# DEVELOPMENT FACILITATIVE TEAM (DFT)

**PR-2022-007805** (Second Submittal)

SI-2024-00849 – SITE PLAN DFT

**Project Name:** *Roses Southwest Papers – Crick Crossing between Watson SE and Hawking SE*

SHEET TITLE
Irrigation Plan

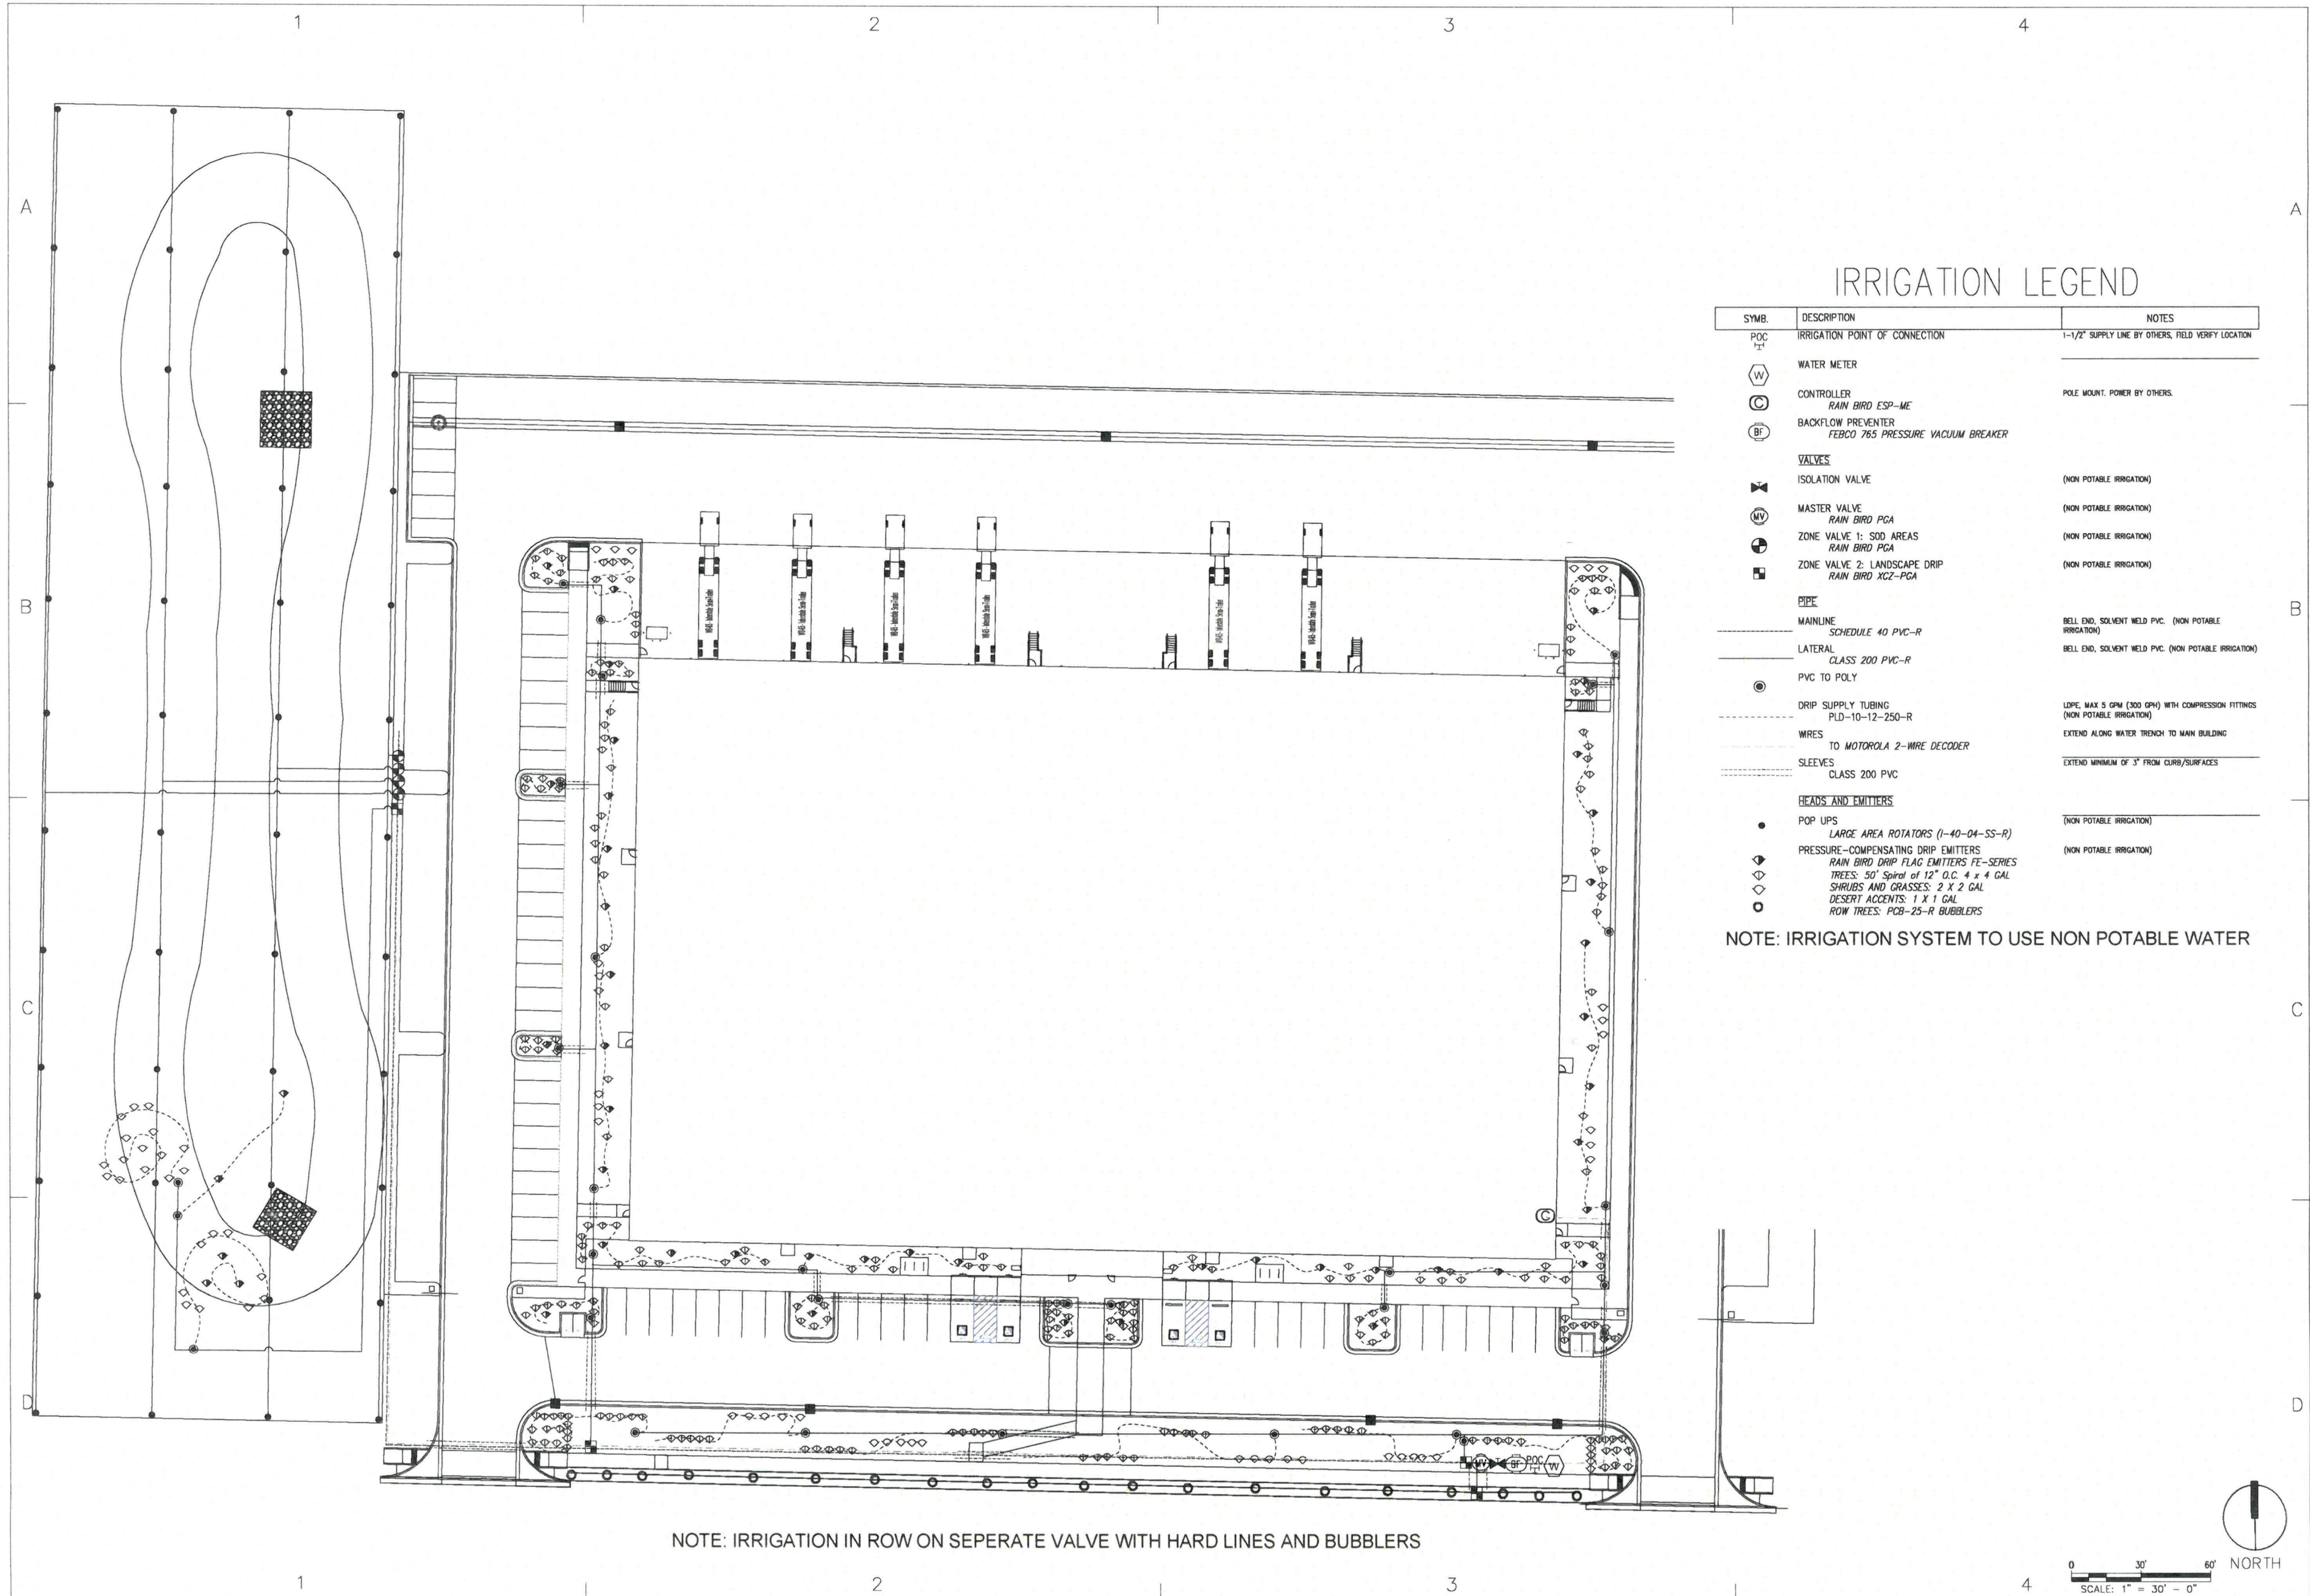
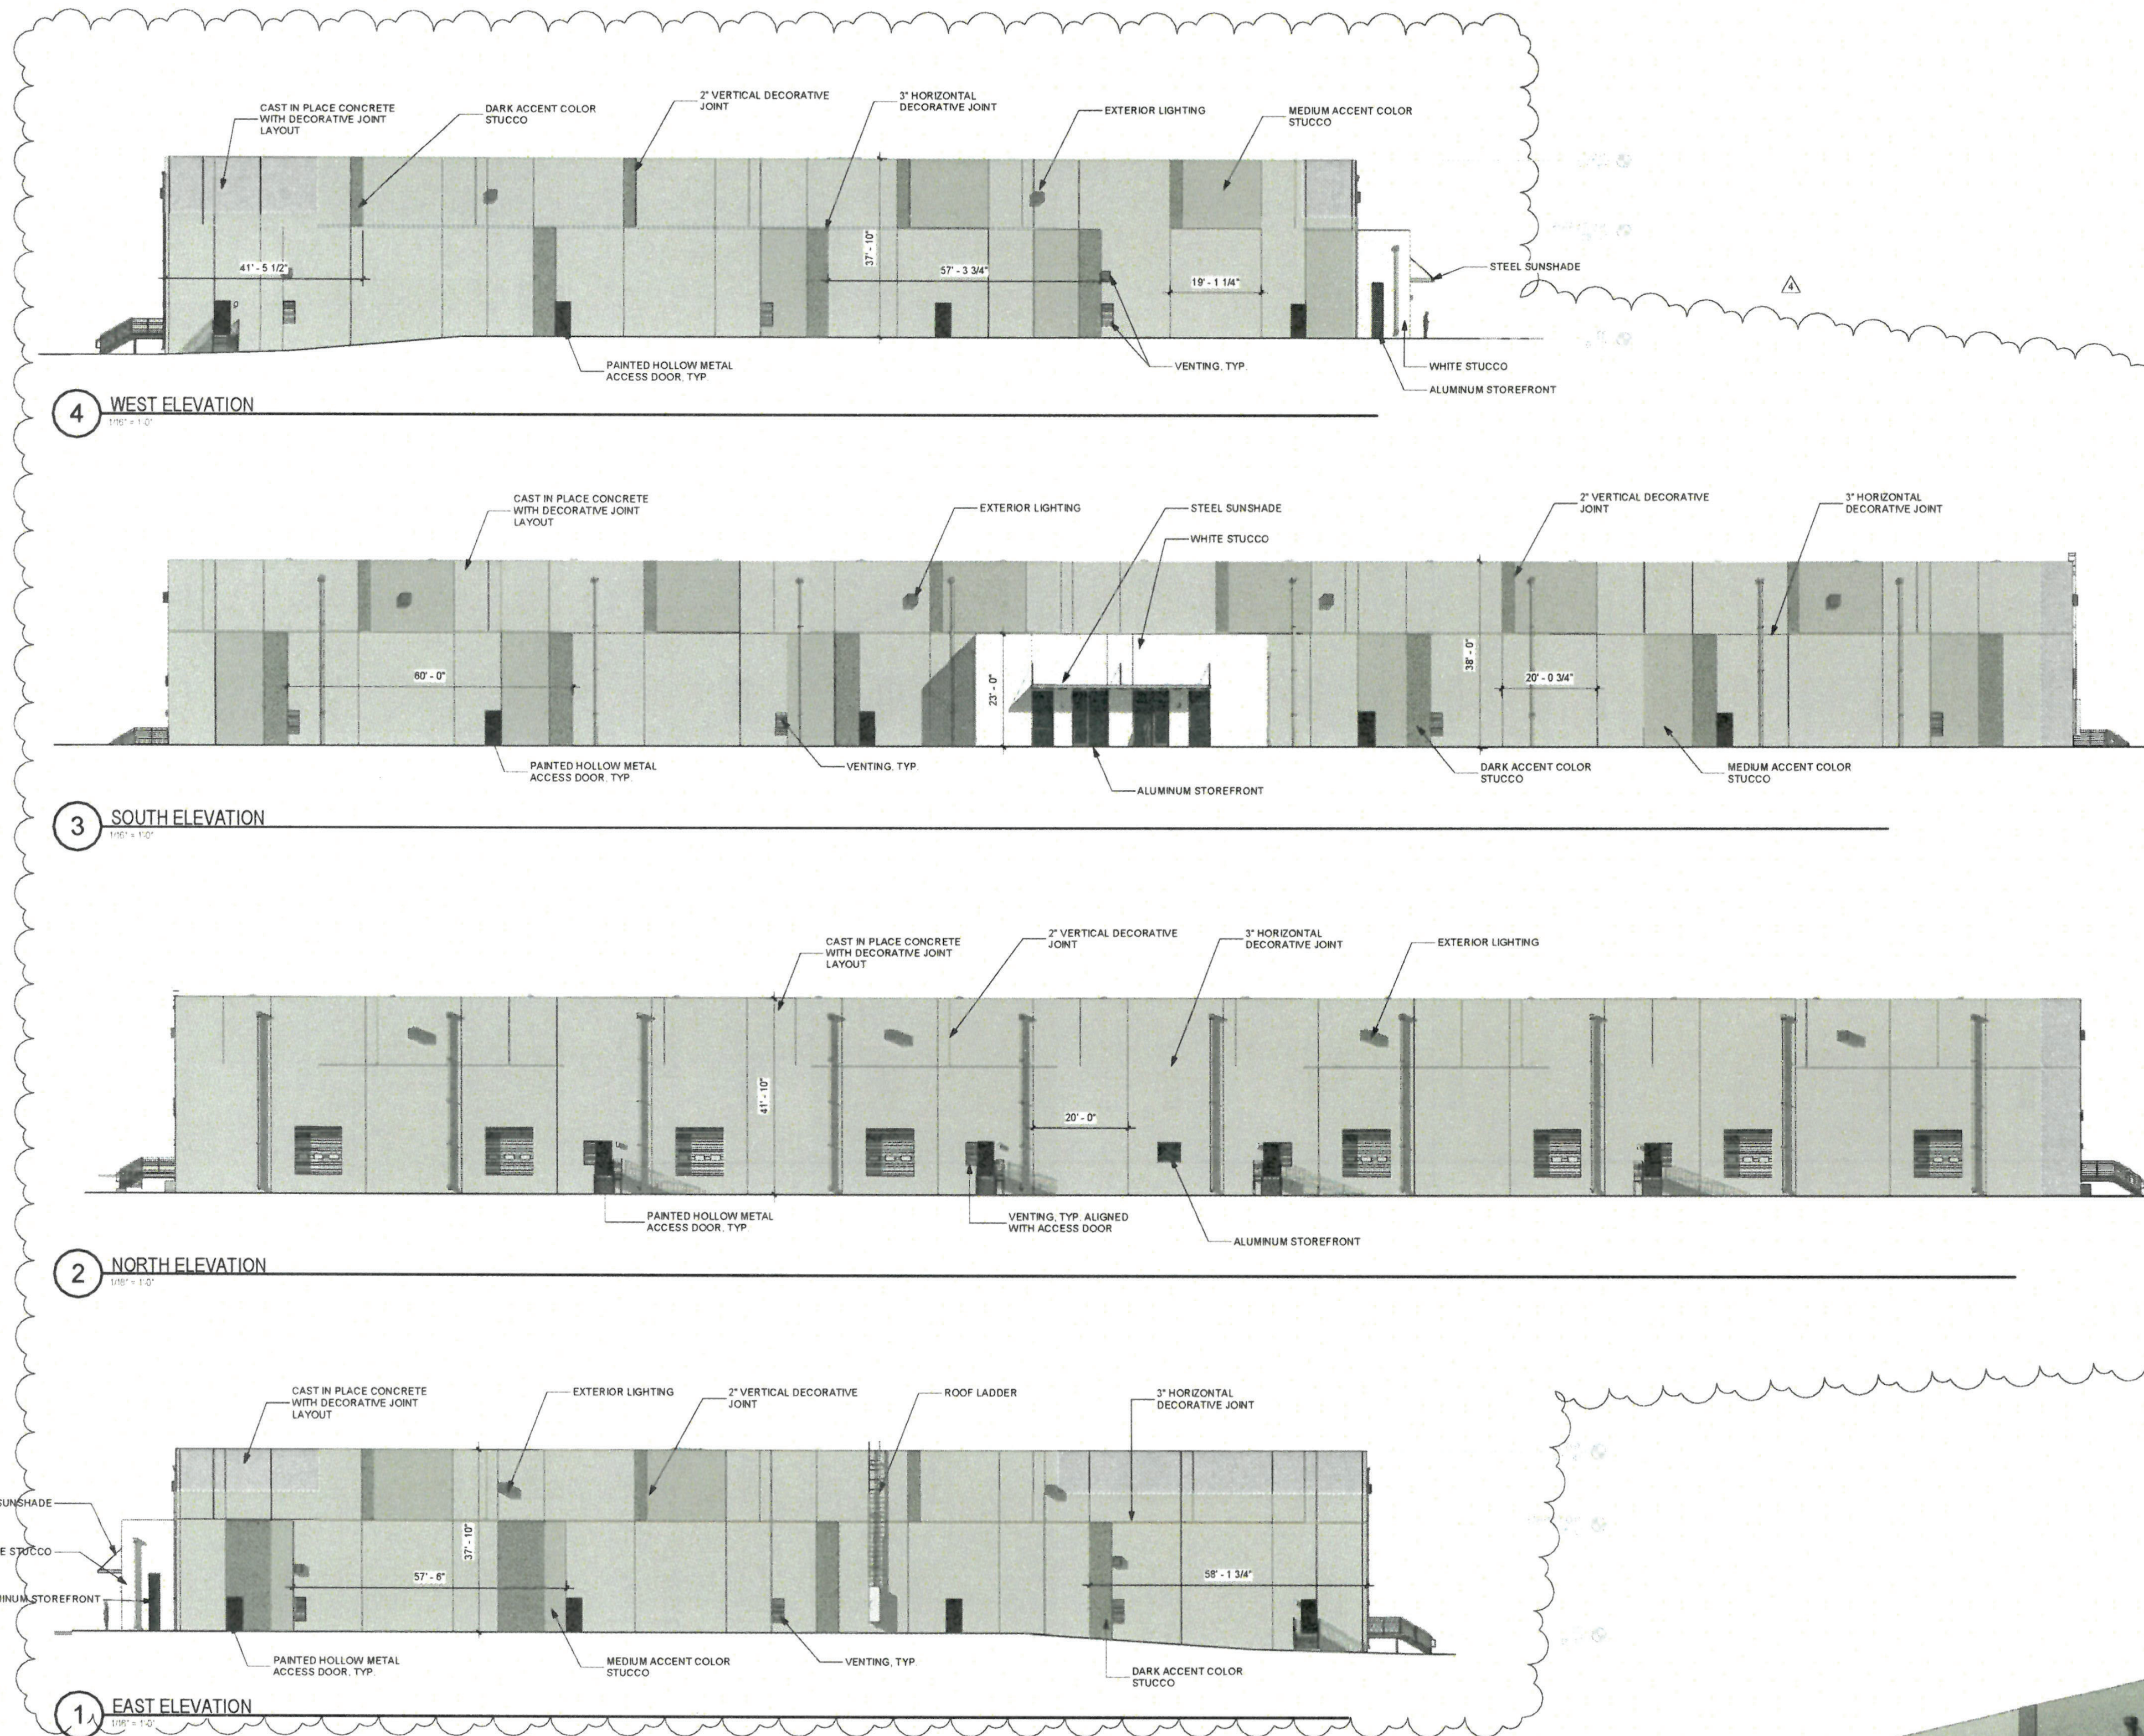
1. Landscape requirements apply to surface parking only.
2. Required parking area trees may be of a deciduous or evergreen species.
3. Landscape coverage: 50% of all tree canopies shall count towards the requirement that 60% of landscape areas be covered with living, vegetative materials. **Landscape coverage must be provided on the plant legend and relevant calculations must be added to the landscape data.**
4. Water harvesting areas for surface runoff shall be provided in parking lots. Permeable paving can be counted toward this requirement. **Confirm compliance**  
**-Landscape calculations seem to be inconsistent. Provide accurate landscape calculations.**  
**See revised Landscaping Sheets.**

a) Irrigation: All irrigation systems shall be designed to accommodate non-potable irrigation.

This note has been added to the irrigation plan.
